**TO:** Nell Donaldson, Planner  
**FROM:** Lauren Swett, PE  
**DATE:** July 14, 2016  
**RE:** 23 Ocean Ave, Level III Site Plan Application

Woodard & Curran has reviewed the Level III Site Plan Application for the proposed redevelopment located at 23 Ocean Avenue. The project includes the construction of a new mixed use building and associated site improvements.

**PERMEABLE PAVER DETAIL (PATIO AREA)**  
NOT TO SCALE

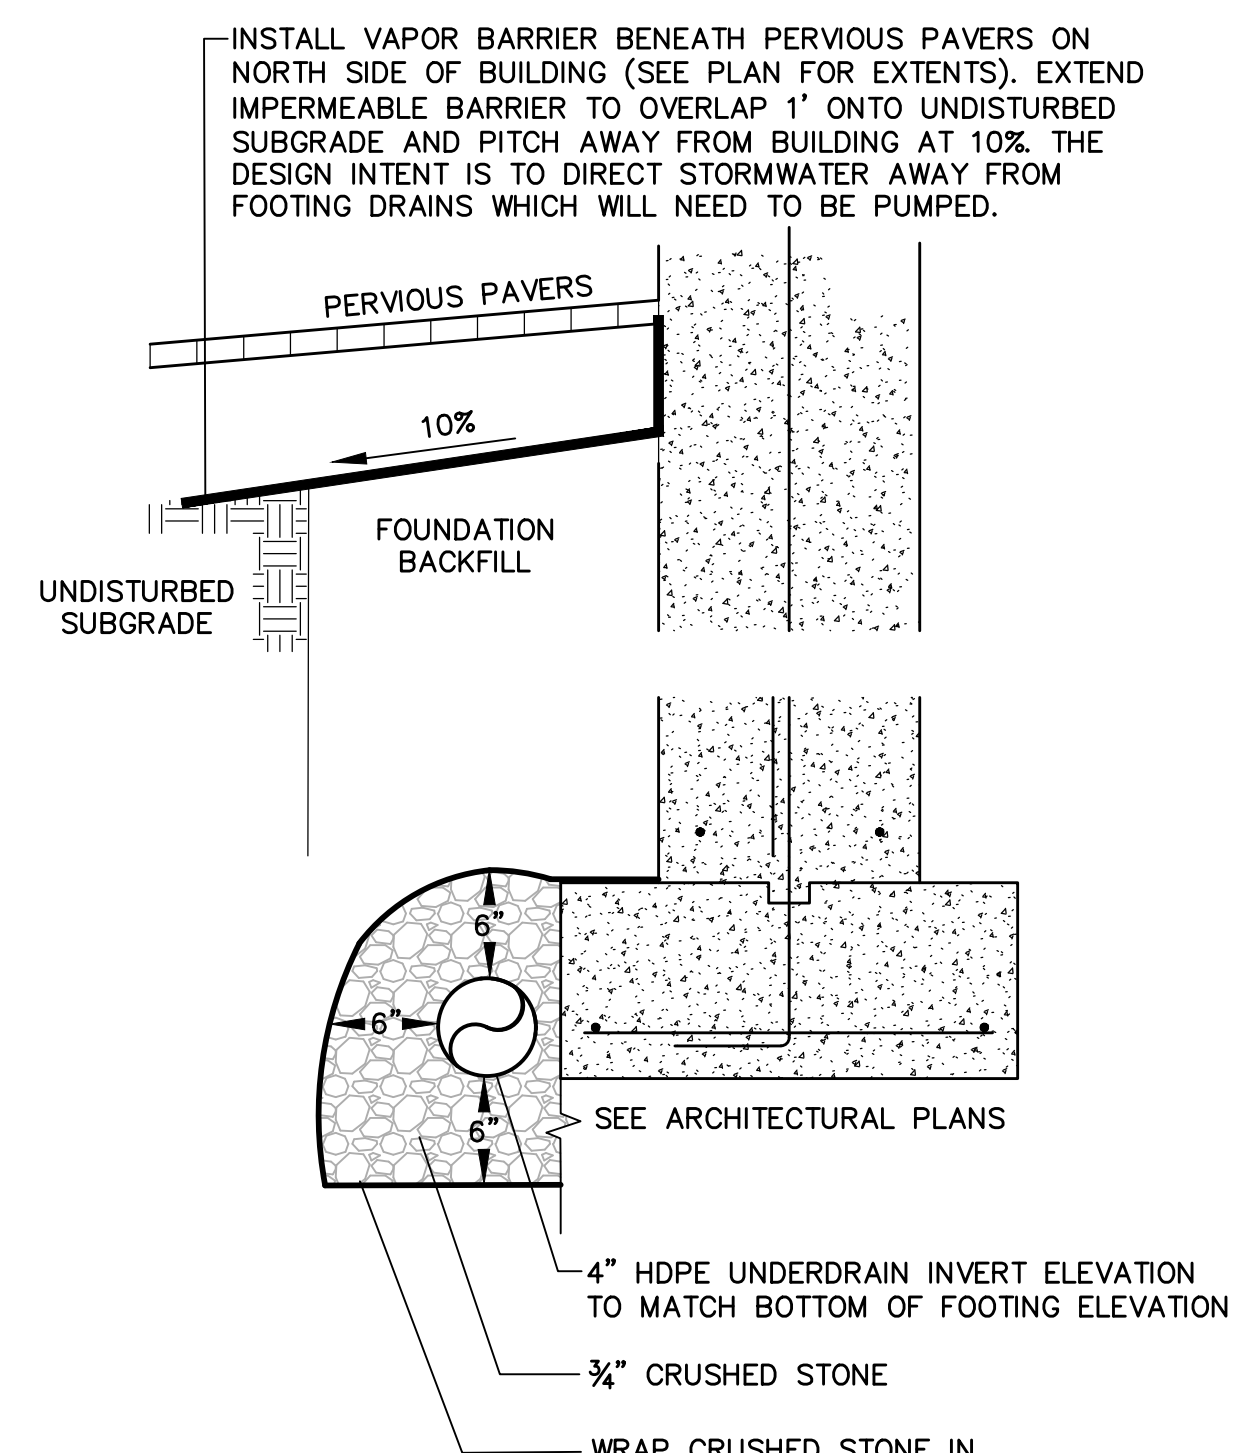
- b) General Standard: The project is required to include stormwater management features for stormwater quality control. The Applicant is proposing to install rain gardens, pervious pavers, and underdrained roof drain collection systems on the site.

- The proposed systems are anticipated to provide acceptable stormwater treatment, but the Applicant is required to provide calculations and additional design information verifying compliance with the Maine DEP Chapter 500 and City of Portland Technical Standards Section 5.

**STABILIZED CONSTRUCTION ENTRANCE**  
NOT TO SCALE

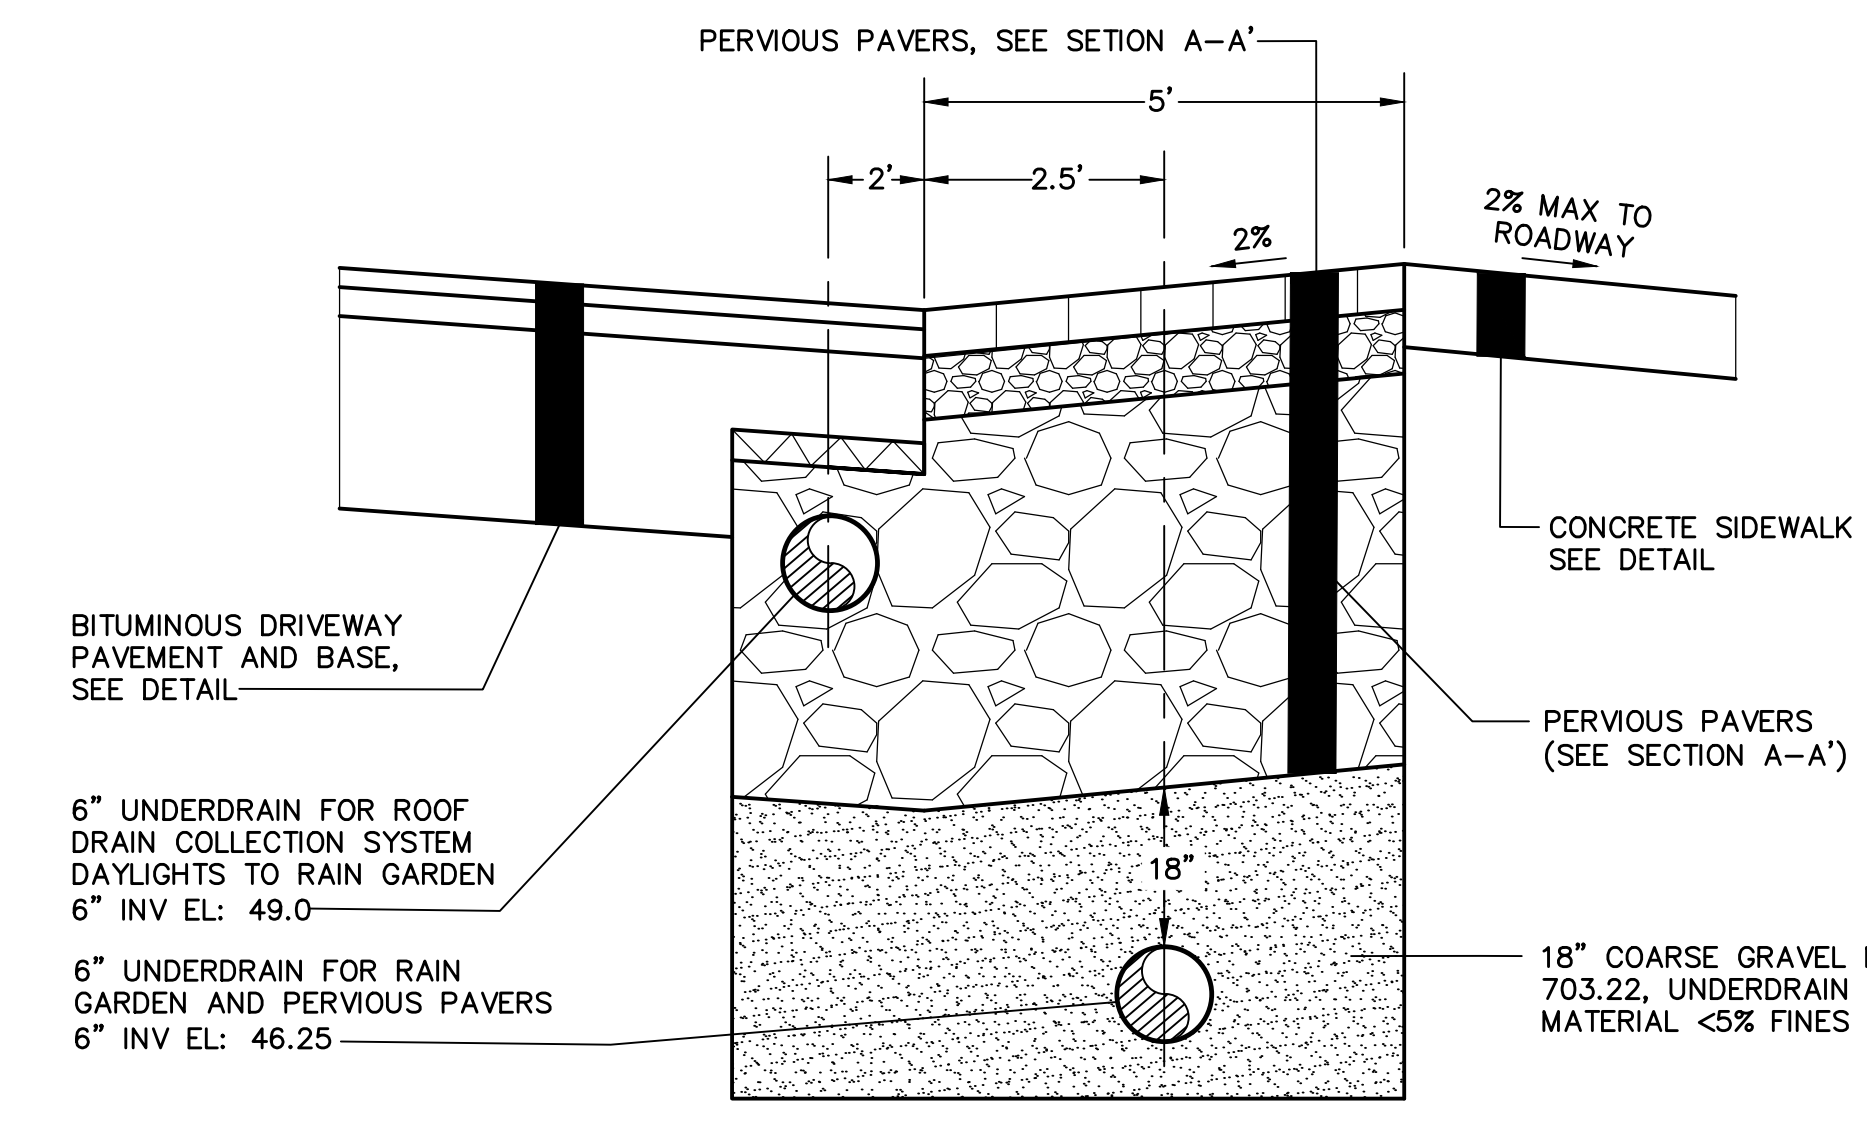
- a) Basic Standard: Plans, notes, and details should be provided to address erosion and sediment control requirements, inspection and maintenance requirements, and good housekeeping practices in accordance with Appendix A, B, & C of MaineDEP Chapter 500. The applicant has provided details, and notes indicating erosion control requirements, but we recommend the addition of erosion and sedimentation control locations on the plans and additional notes on inspection and maintenance requirements should be added to the plans to be in conformance with the standards.

**SHALLOW RAIN GARDEN AREA**  
NOT TO SCALE

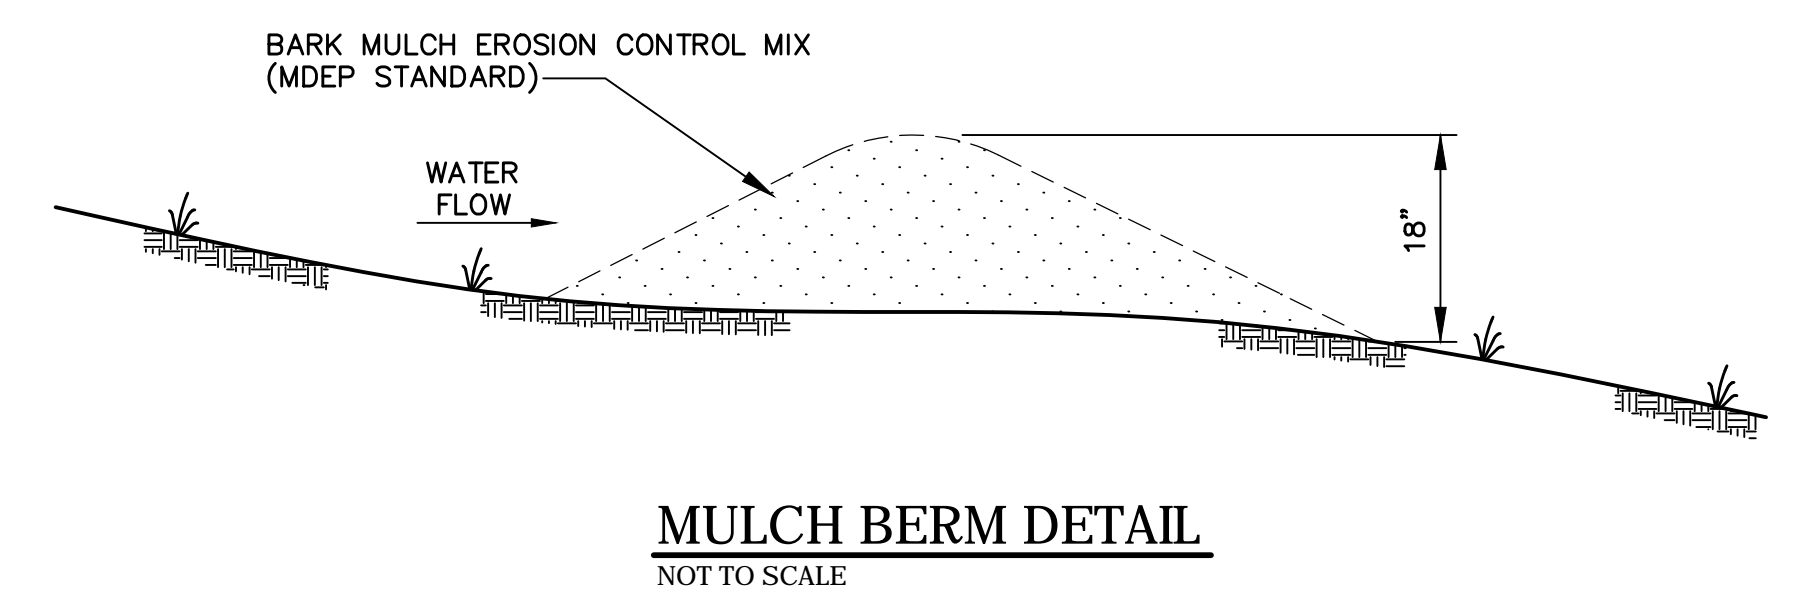
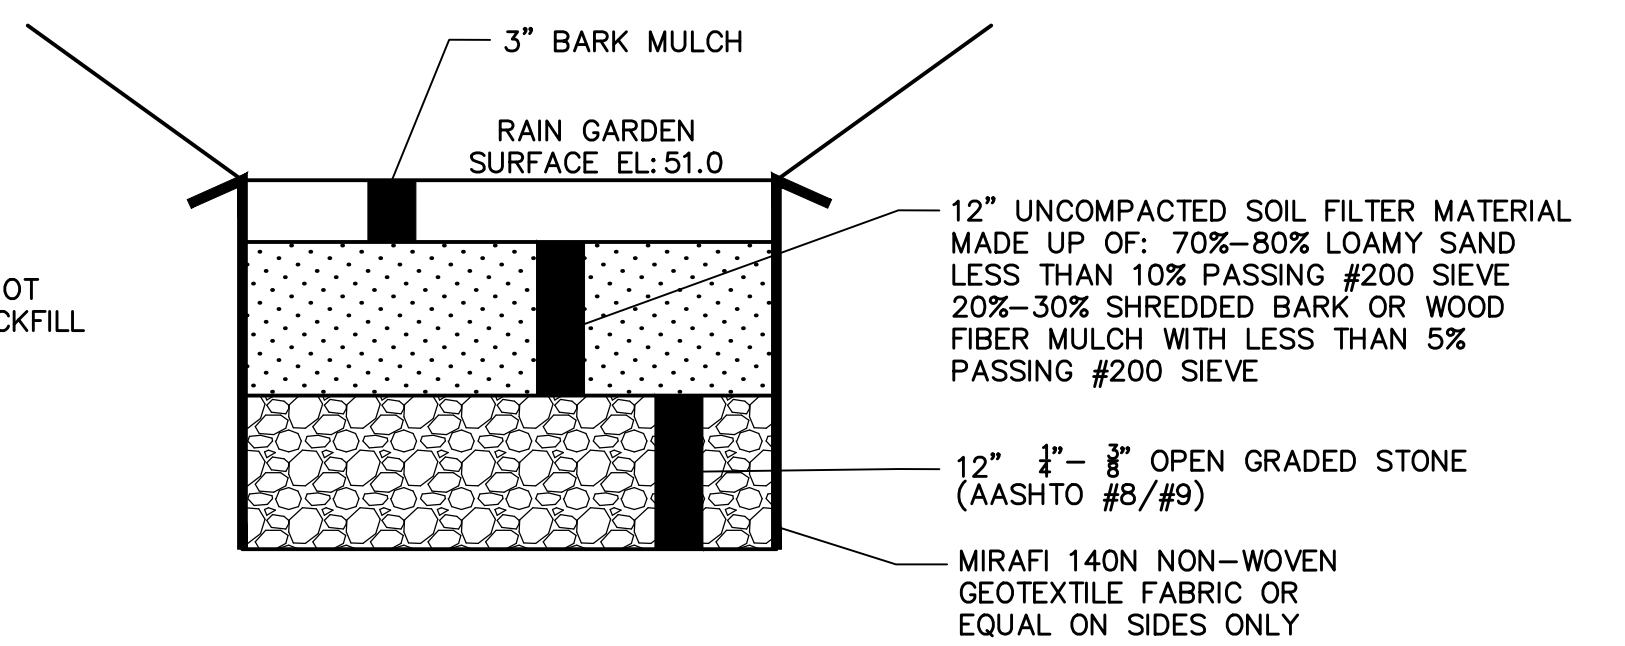
- The proposed rain gardens do not appear to have any overflow structures or bypass outlets. Applicant should provide model and information indicating the peak water elevations within these systems during storm events, as well as information on infiltration rates at these sites. The Applicant should provide comment on the potential for these systems to overflow during storm events, and the impact that this may have on their site and adjacent properties.

UNDERGROUND ELECTRIC/COMMUNICATIONS UTILITY TRENCH DETAIL
NOT TO SCALE

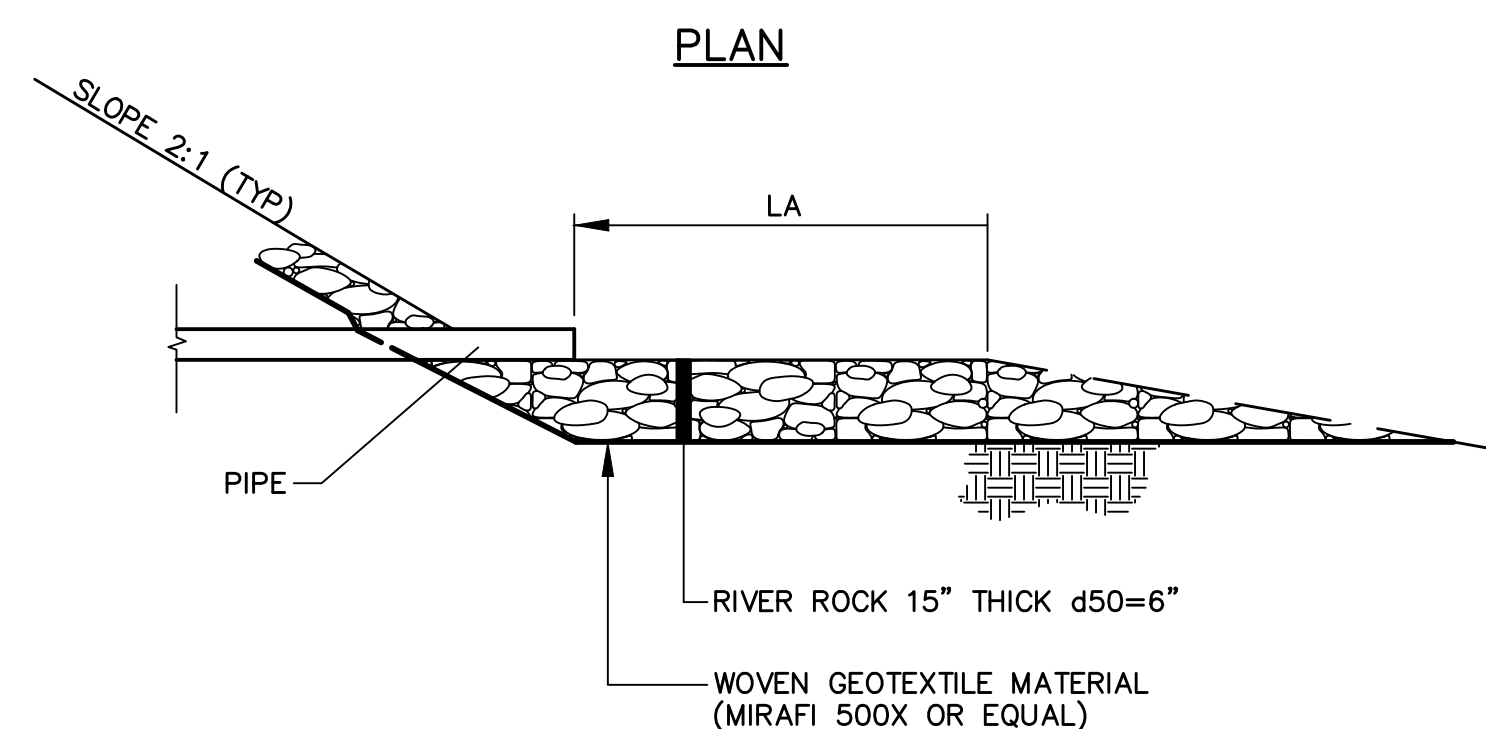
- 3) The proposed underground gas and electric utilities will be located beneath an existing hedge located along Ocean Avenue. The site preparation plan notes that the hedge is to remain, and the landscaping plan does not provide any new plantings in this area. The Applicant should comment on the plan for maintaining this existing landscaping with the proposed utility installation
